ATTENTION: DIRECTOR – KEY SITE ASSESSMENTS

State Significant Development Application Number SSD-10300.
Coffs Harbour Cultural and Civic Space.

GORDON ST ELEVATION

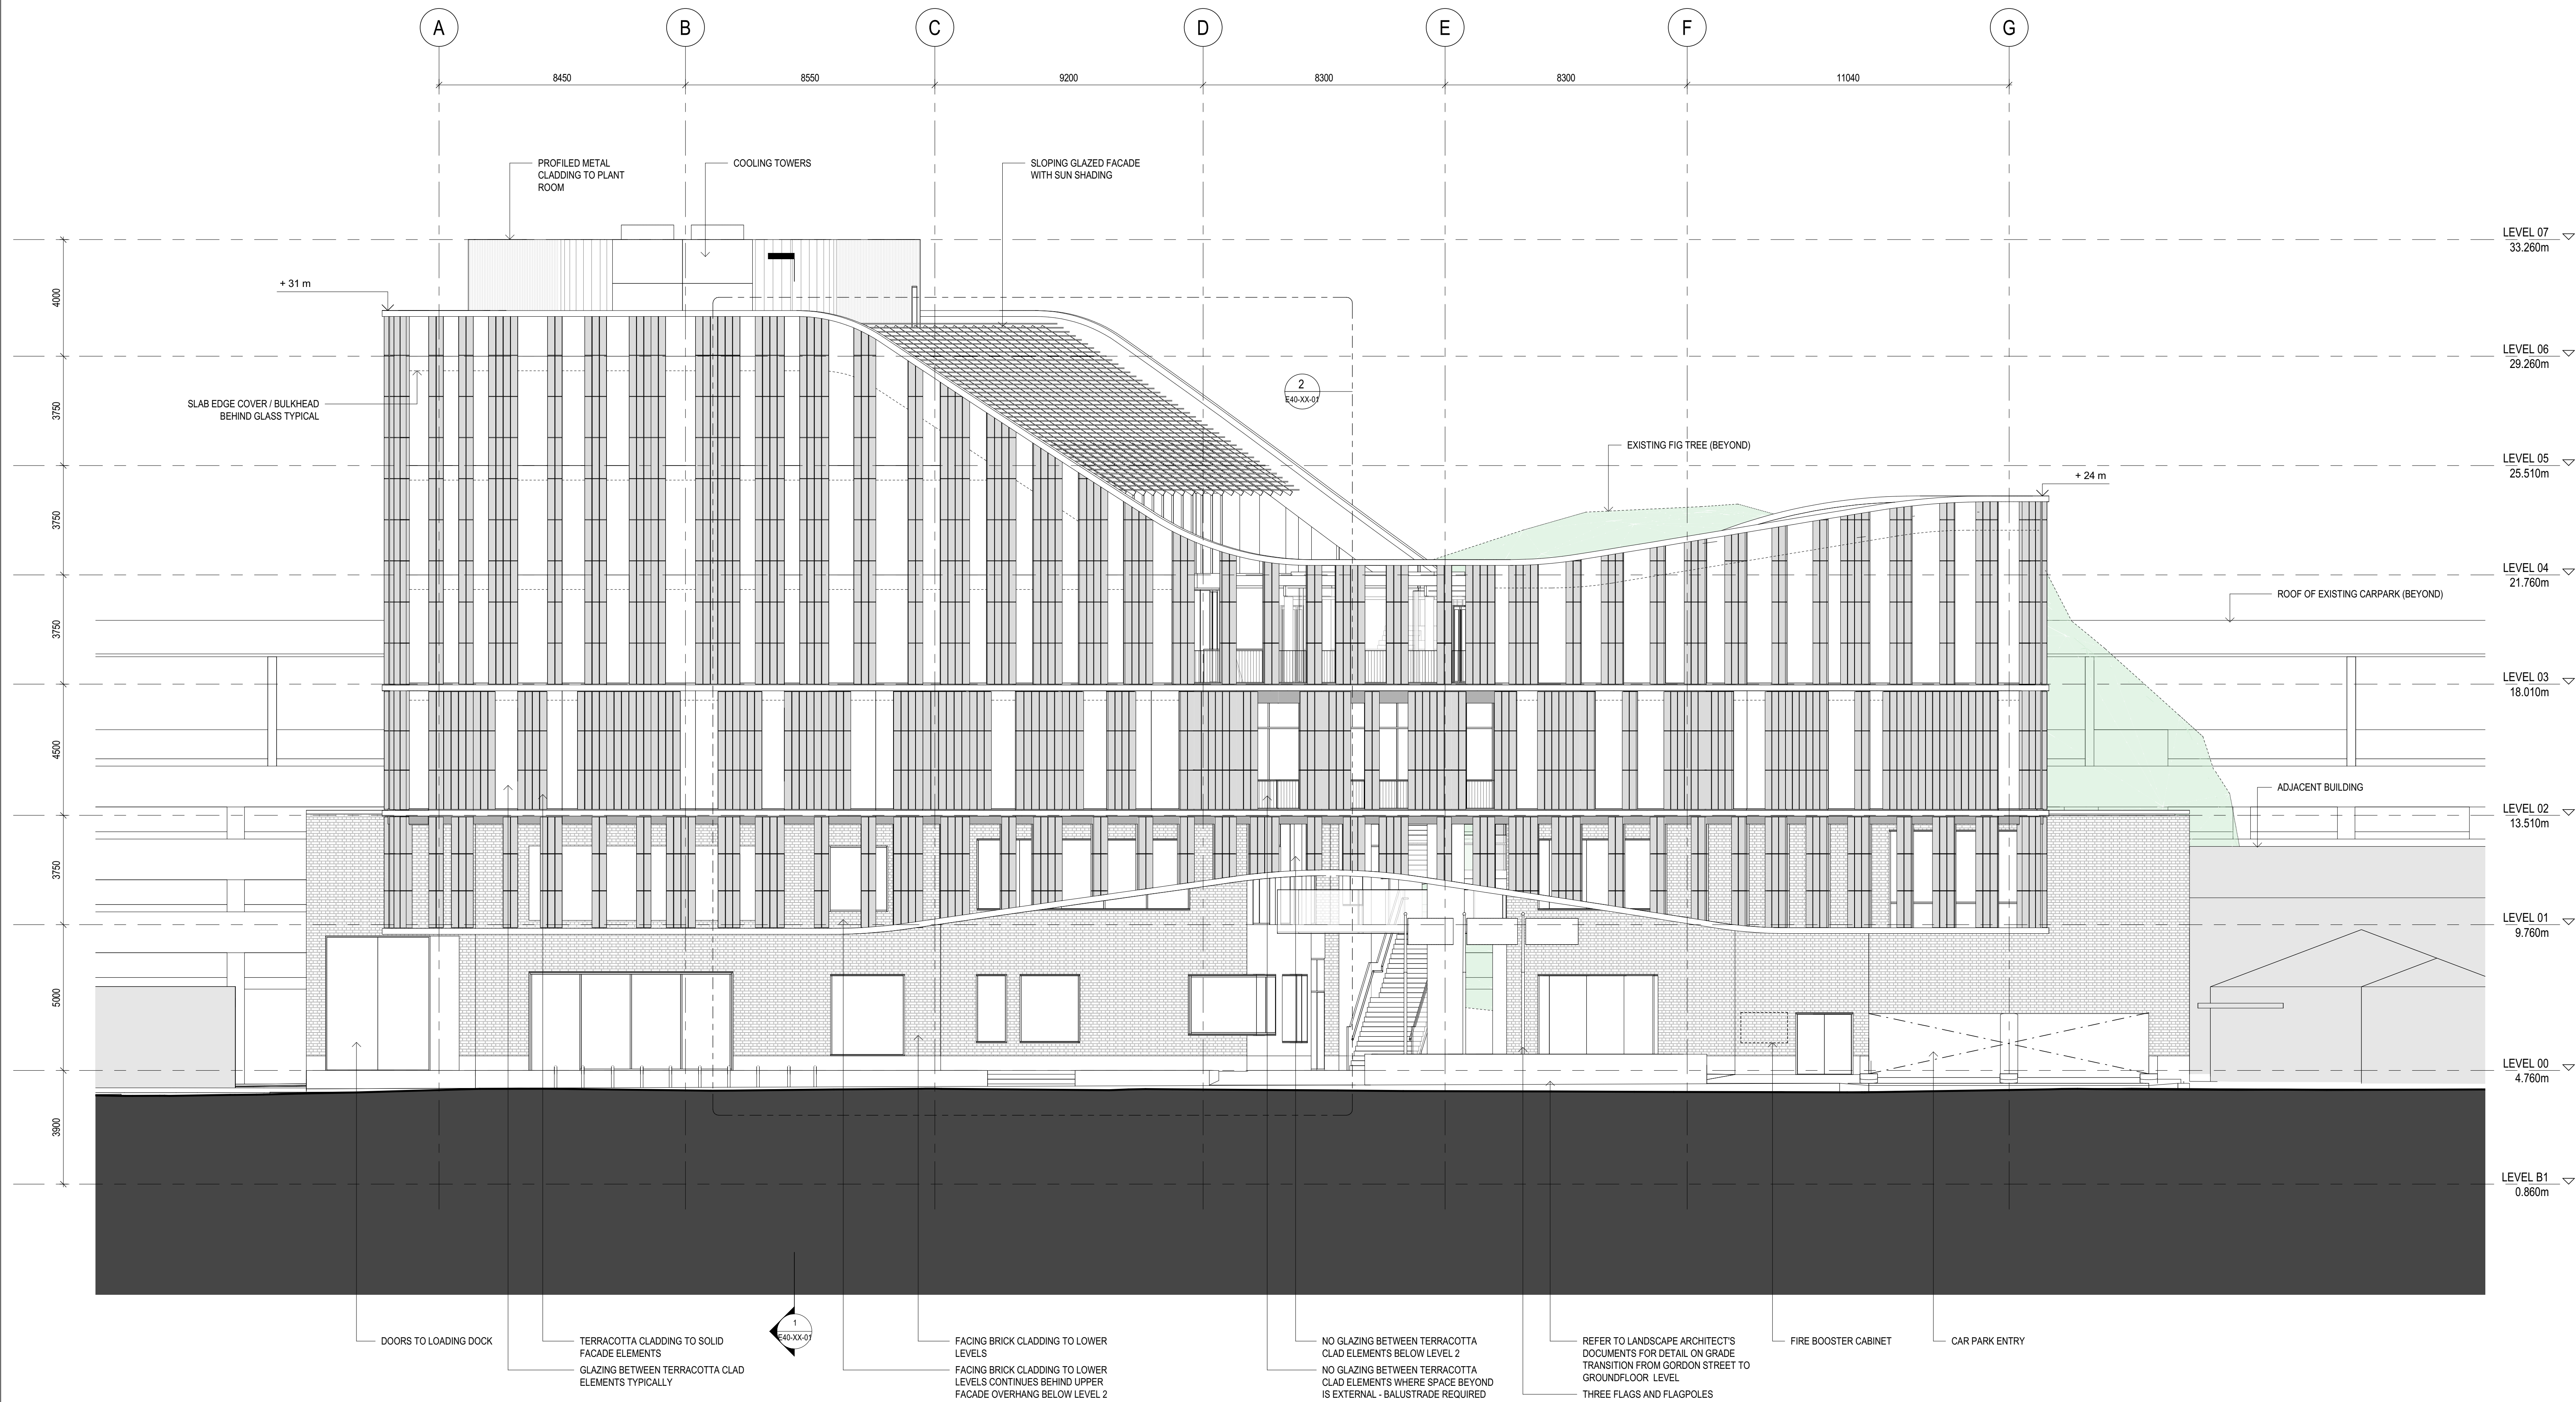
10. It conflicts with the streetscape in Gordon Street in that the proposed building is outside the context of this street having regard to the scale, existing street setbacks, design and general form of the adjoining buildings.
